MADDOX PLANNING

**22/02025/REM: BICESTER GATEWAY PHASE 1B
RESERVED MATTERS APPLICATION TO APPROVED OUTLINE REF: 16/02586/OUT
LANDSCAPING RESPONSE; SECURE BY DESIGN RESPONSE; HIGHWAYS**

01 Type 1 - Elevation and Plan View
SOFT LANDSCAPE TREE PIT DETAIL WITH STAKES

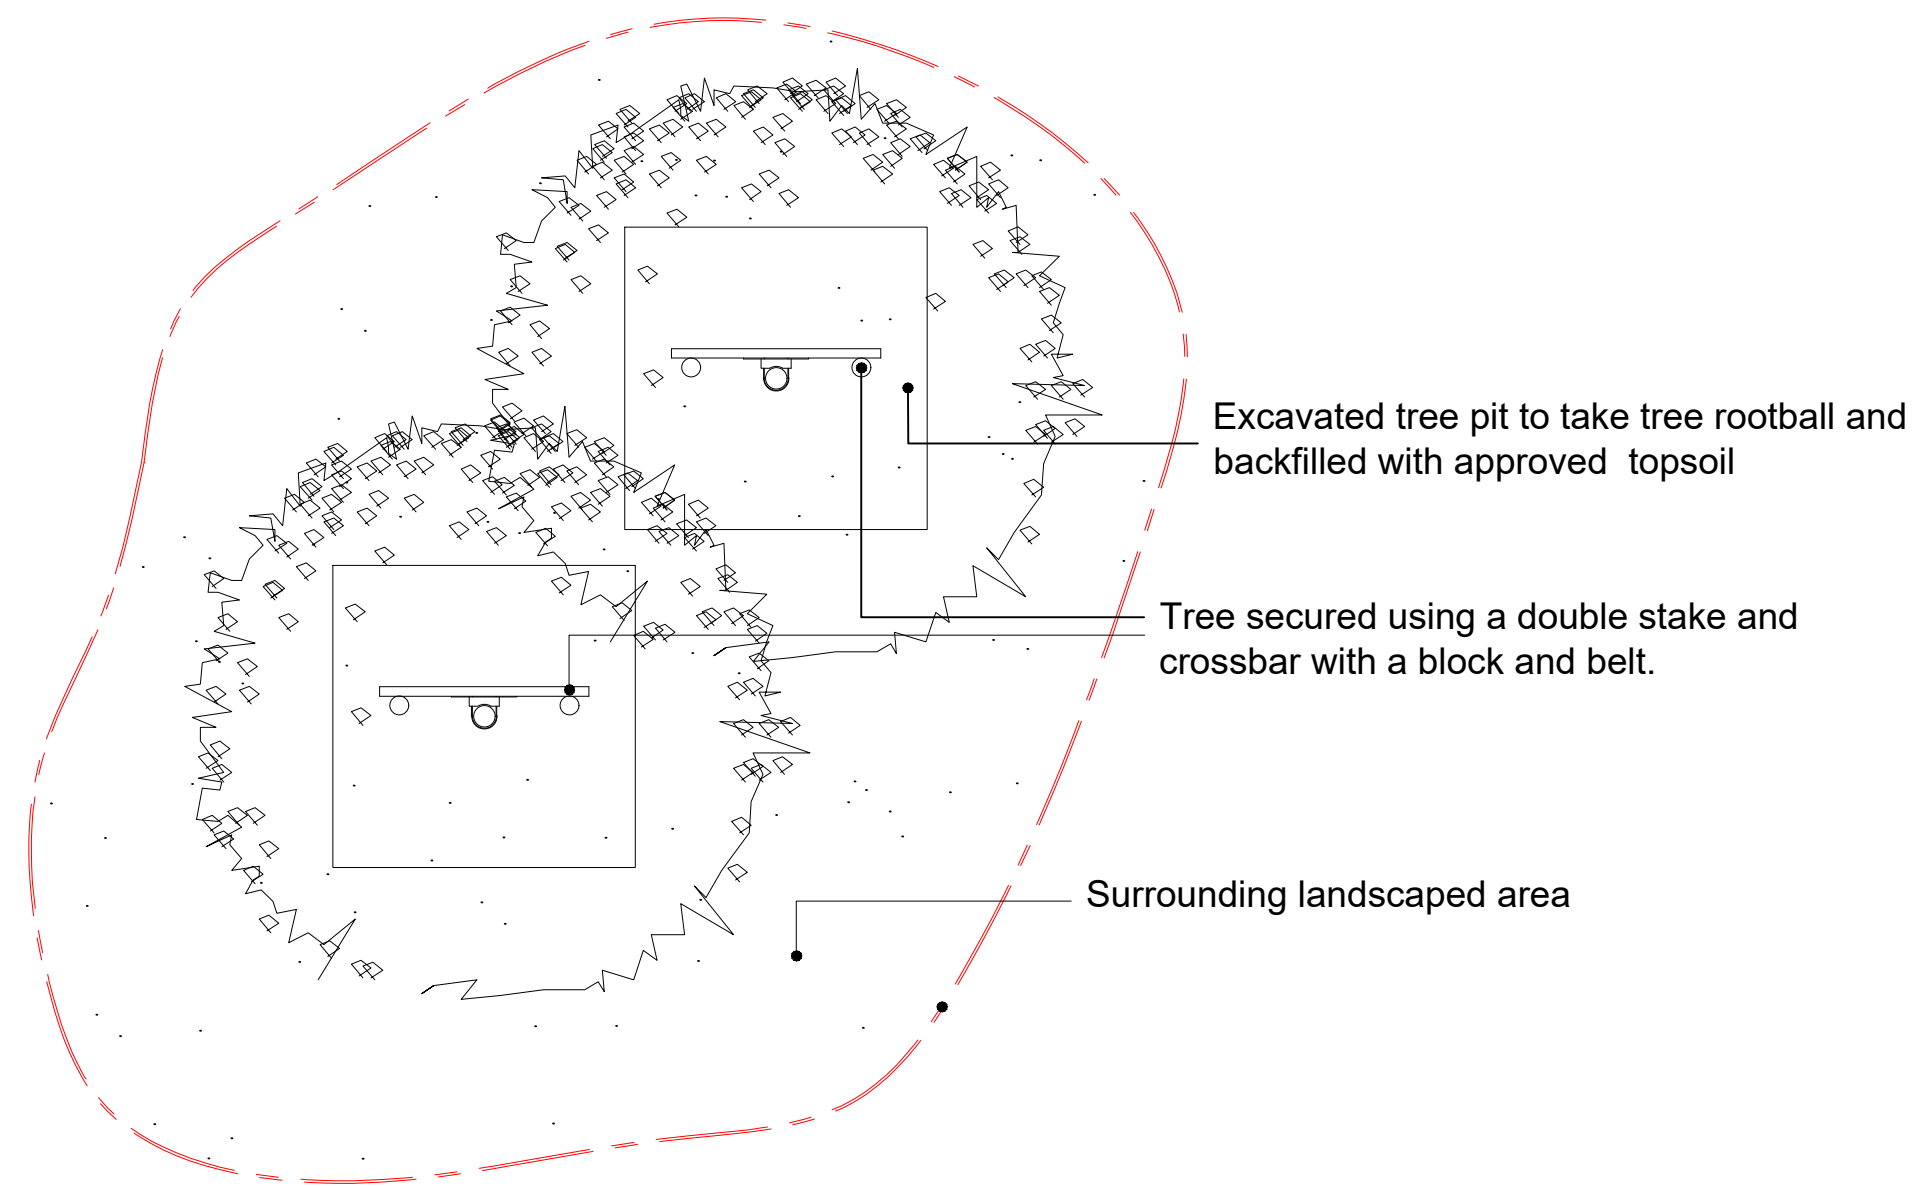
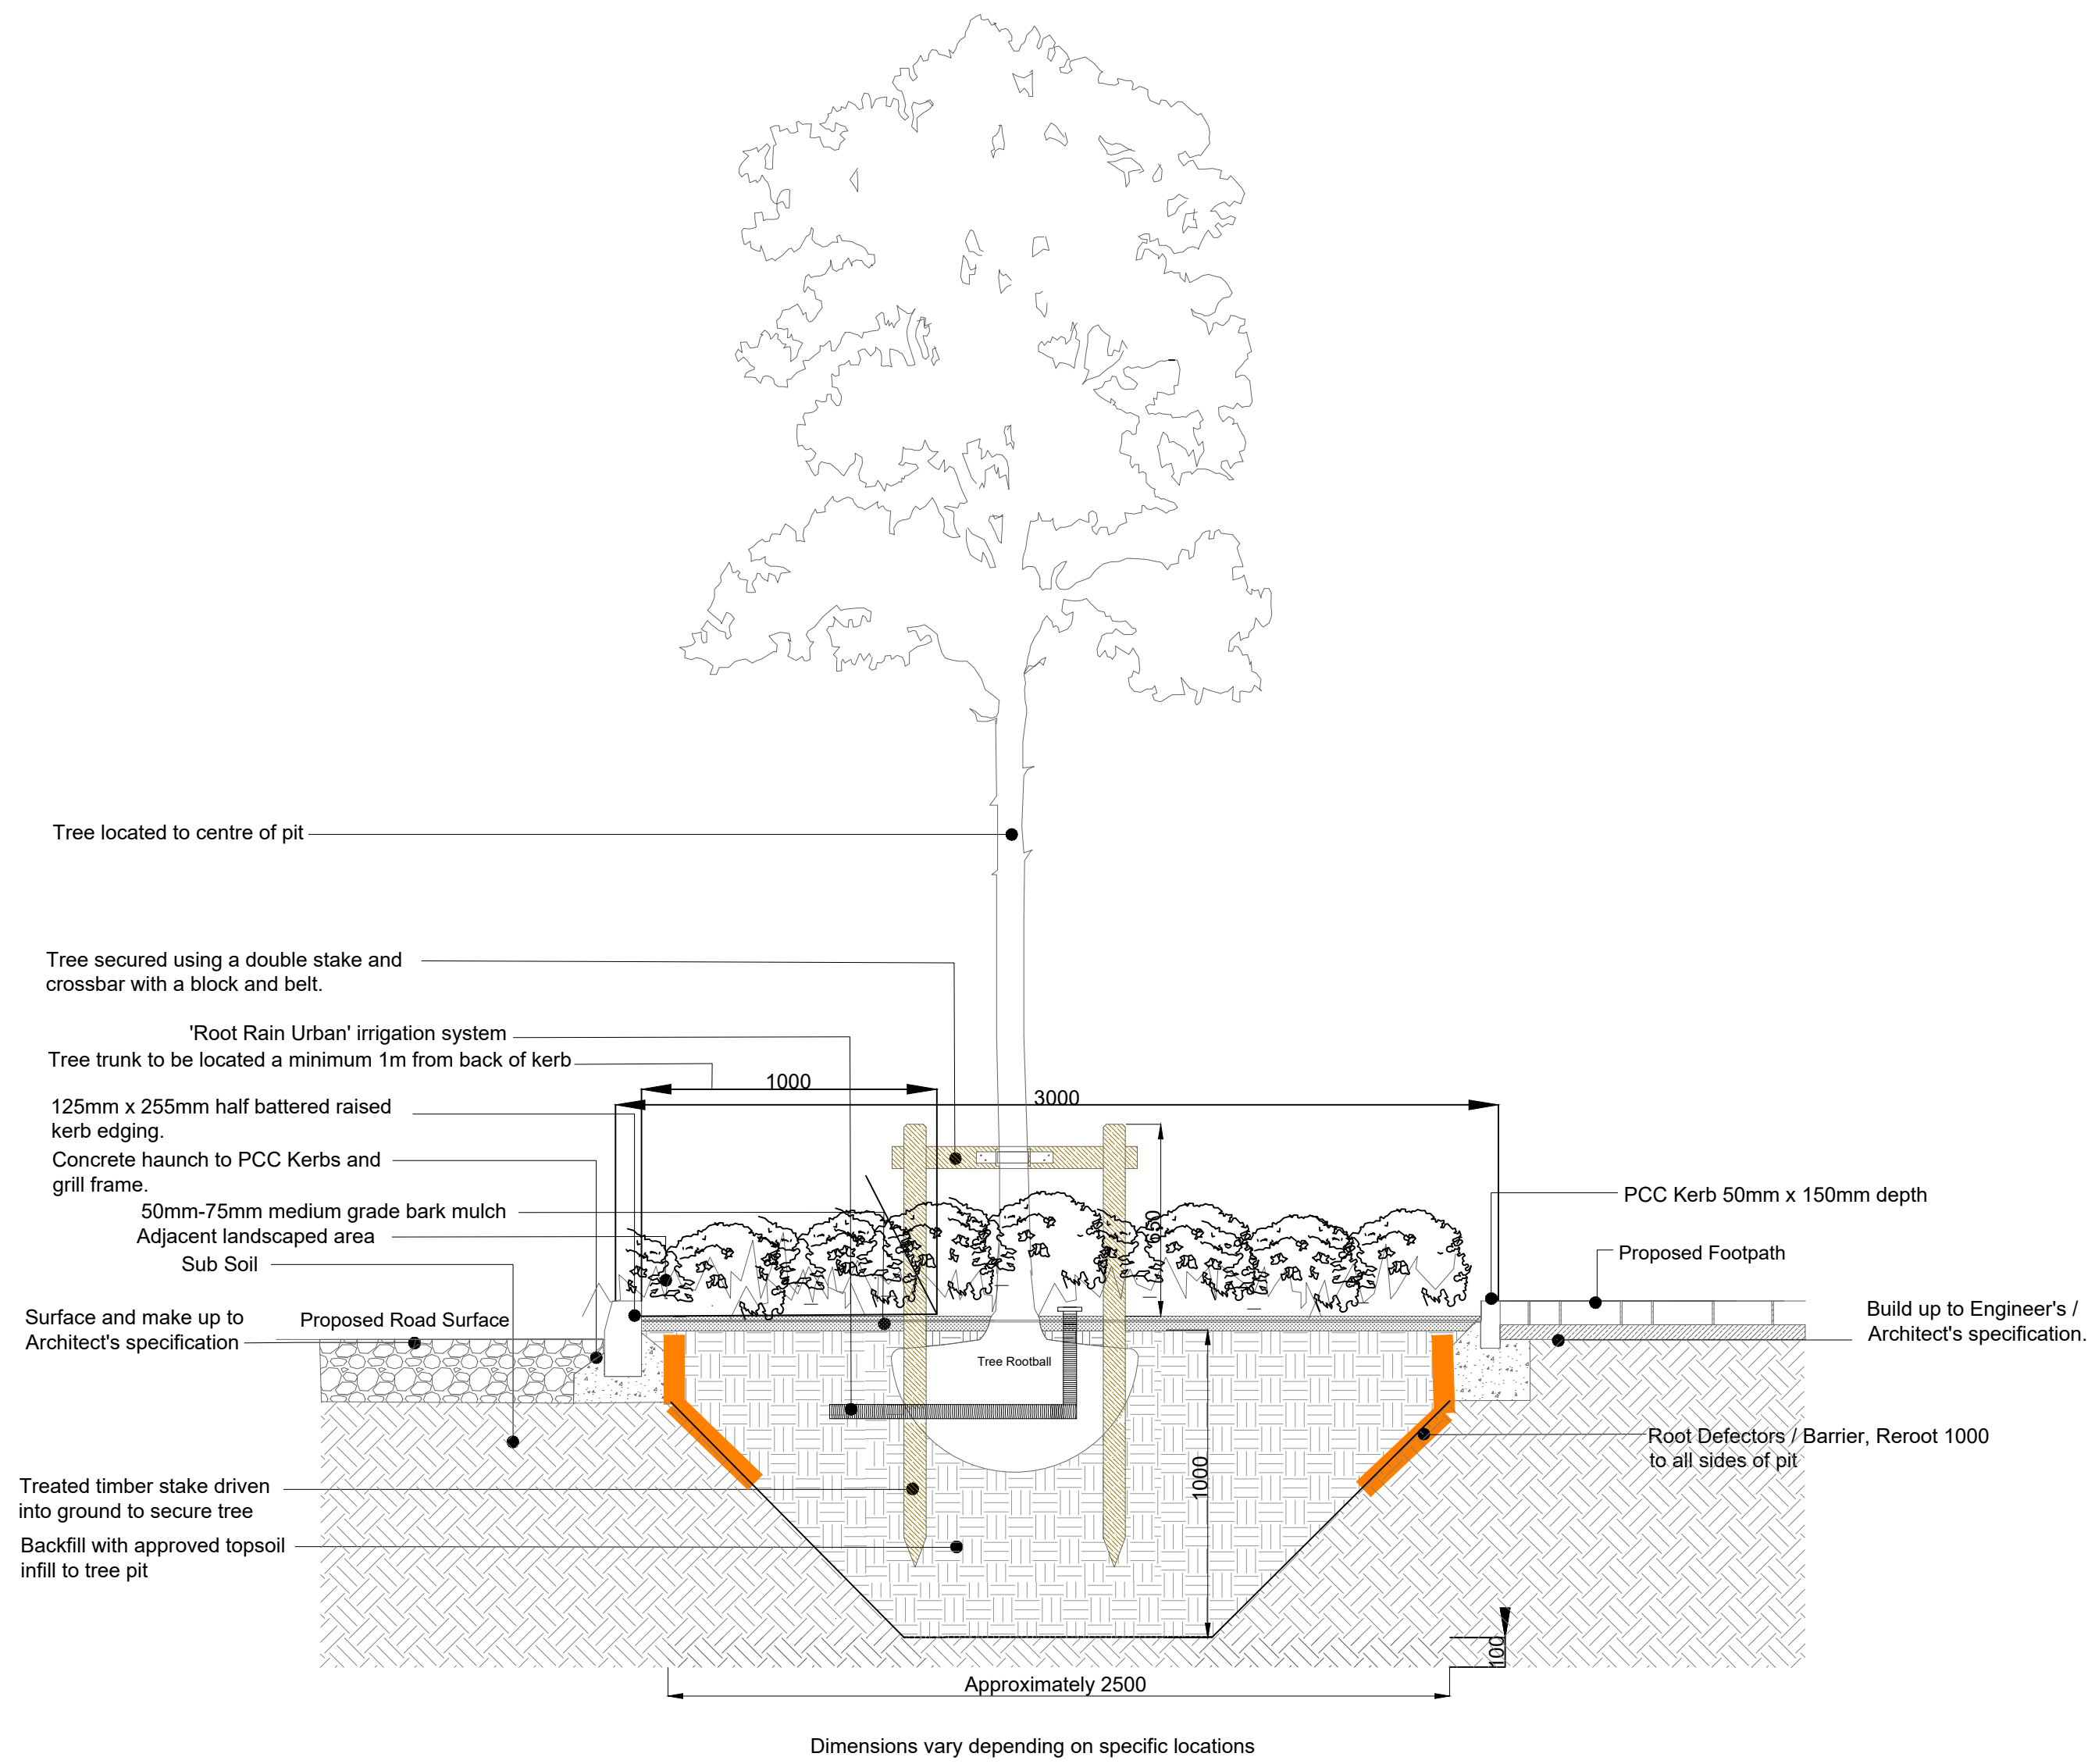
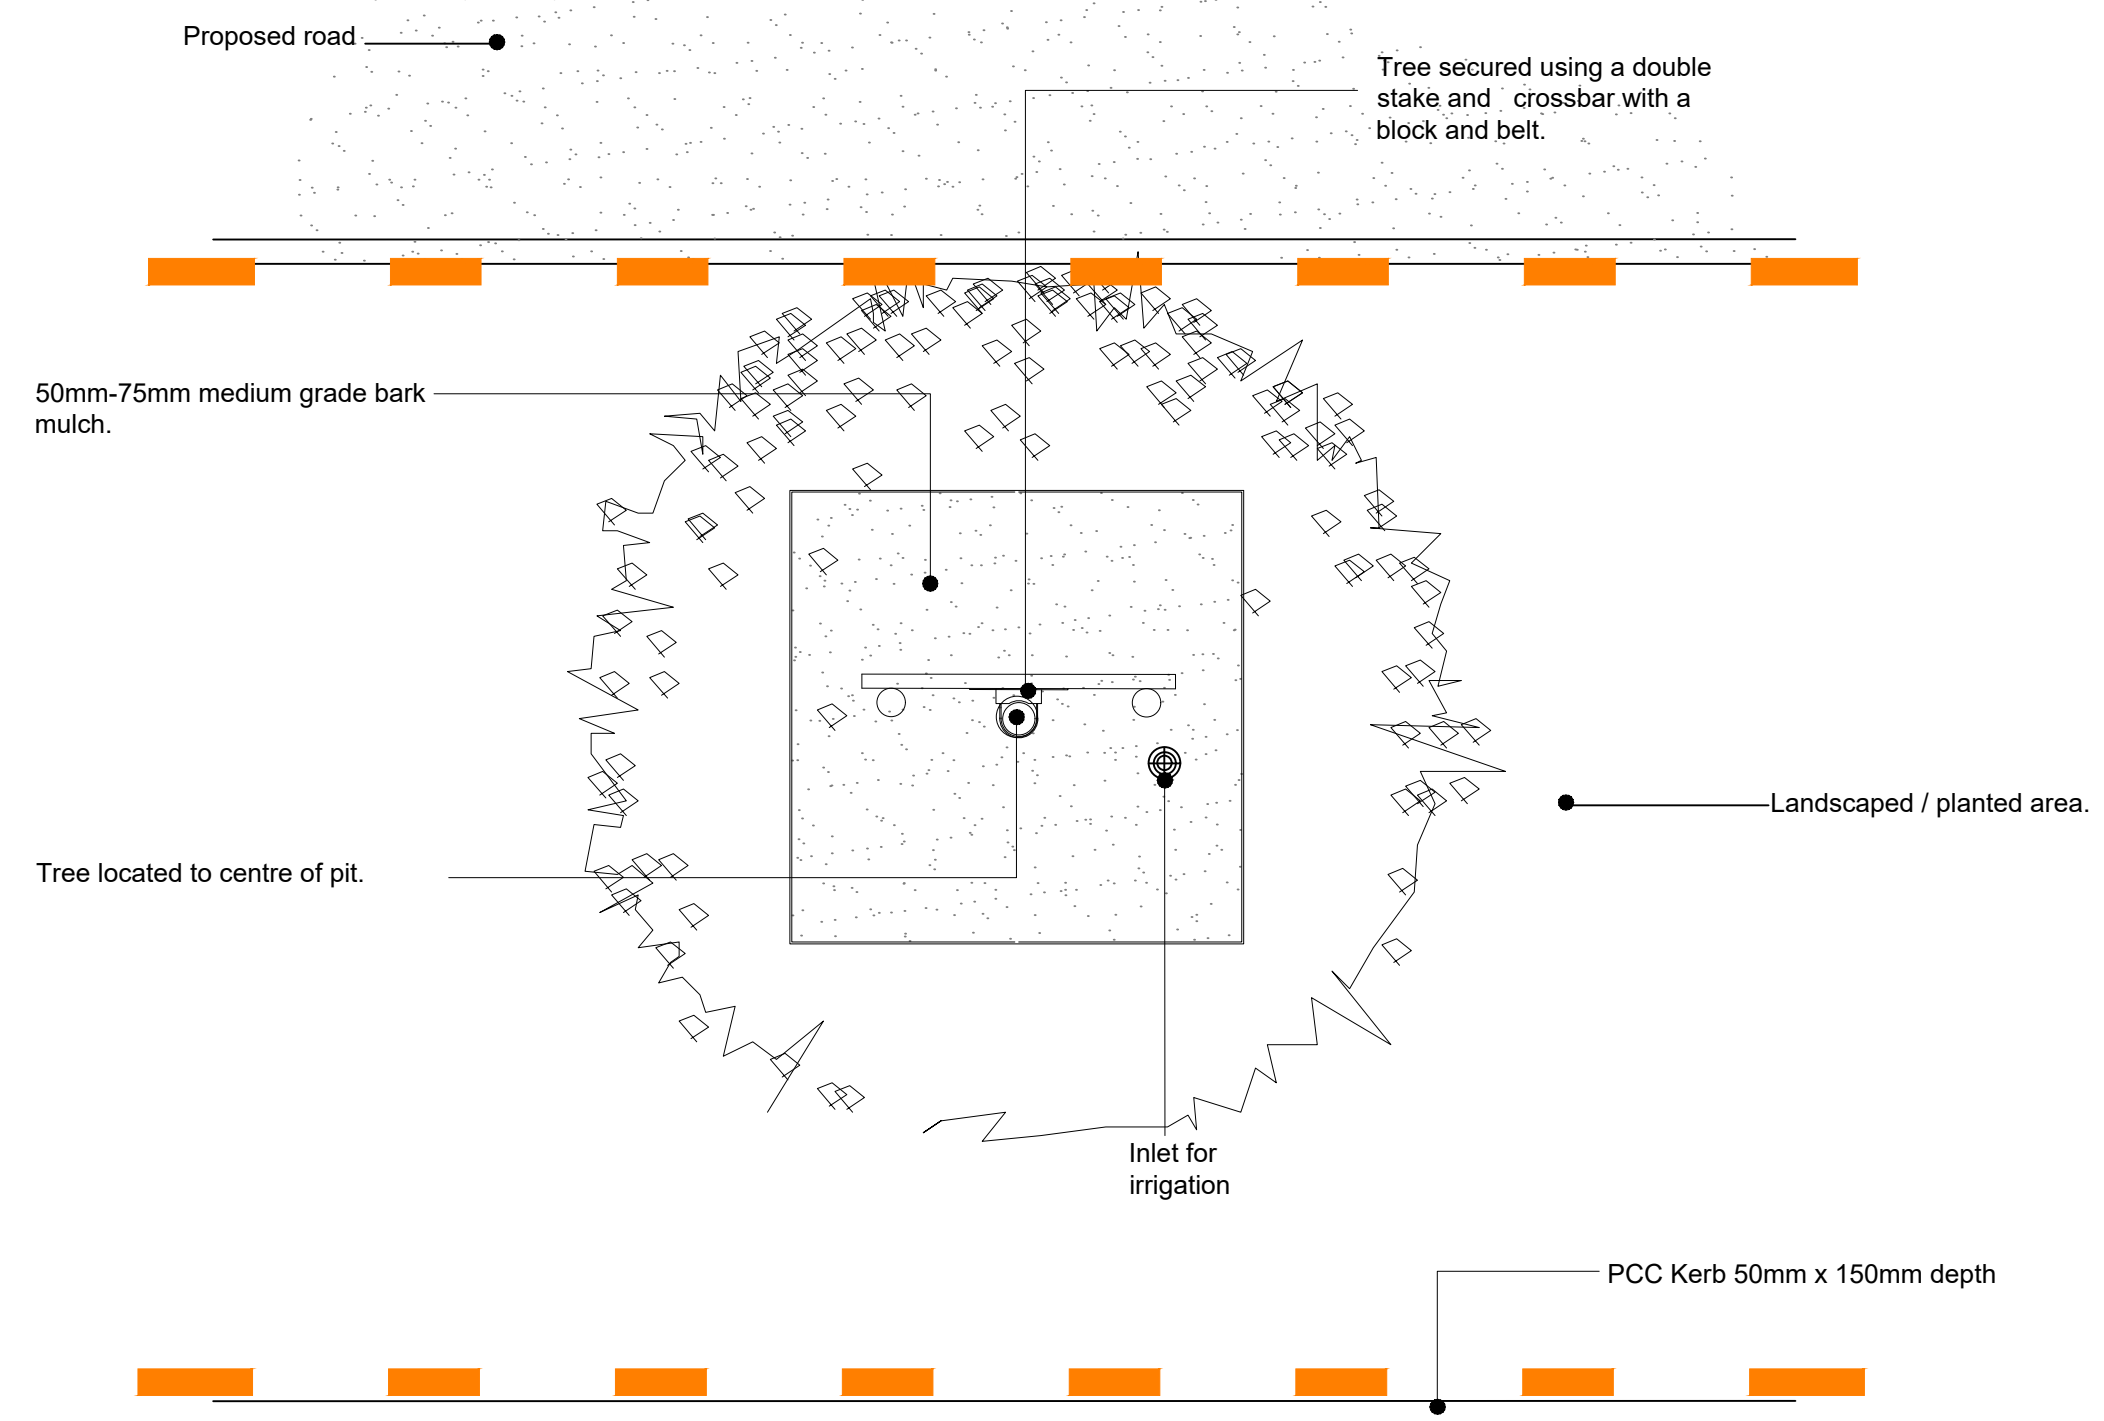
Primary comments relate to requiring additional trees to mitigate the heat Island effect, provide amenity and wildlife value. A marked-up plan accompanies the officer comments. This plan appears to show 16 trees as “new oak trees” on the site. However, these are shown as located within the archaeological priority area, marked on all submission plans as “preservation in situ”.

- Tree pit details and root deflectors are indicated. Full linear beds would be considered to act as the full tree pit bed;
 - Tree species are clearly set out within the planting plans on mounding and elsewhere;

The team has taken comments on board and sought to respond positively. The landscape plans are amended (enclosed) to make the archaeological area “preservation in situ” clearer. The plans and the landscape management plan (LMP) now include the following:
